STATE OF WASHINGTON
DEPARTMENT OF ECOLOGY

May 23, 2008

Thank you for the opportunity to comment during the optional determination of nonsignificance process for the Caribou Creek Corral Horse Camp/Guest Ranch, proposed by Dennis and Phyllis Laukala [CUP 08-07]. We have reviewed the documents and have the following comments.

Approx 1" = 200'

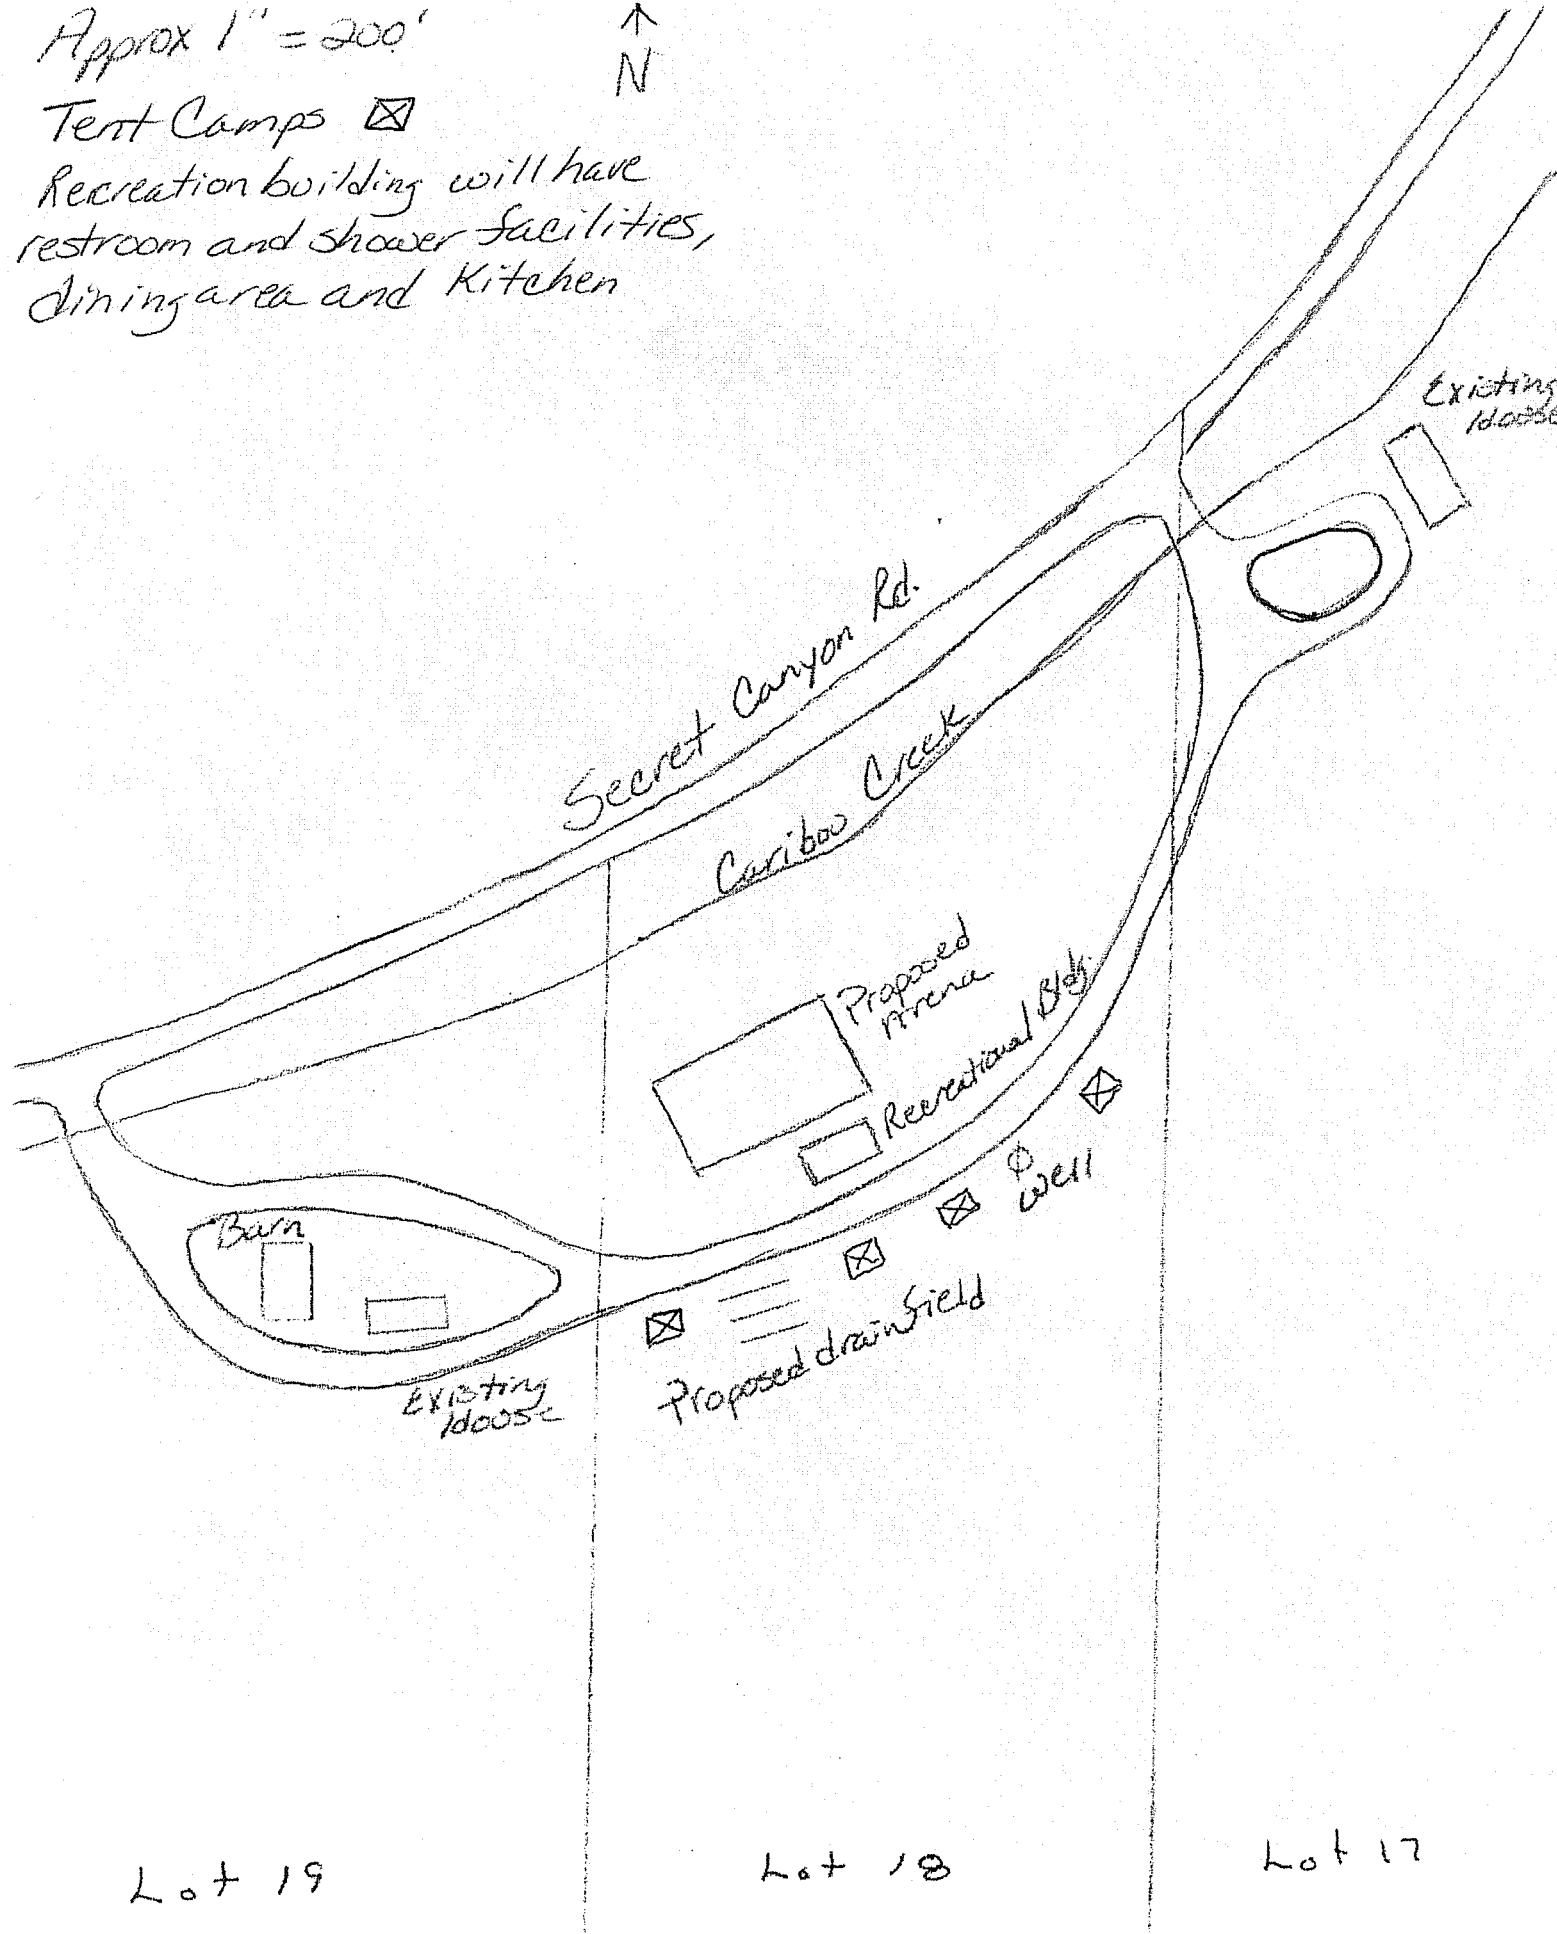
No specific dimensions to the site map were given. If indeed the map is to scale, then it appears that the long house/recreation house are not within the 200 foot buffer, but the environmental checklist for the project notes in item B 3a(2) "Yes, the long house will be within 200 feet of Caribou Creek. Site plan attached." Ecology recommends the proponent provide Kittitas County and Ecology with:

- size of structures (barn, if not existing, recreation building, arena) and
- how far are the structures from the creek

The project footprint is critical in evaluating the environmental impacts of the proposed Guest Ranch.
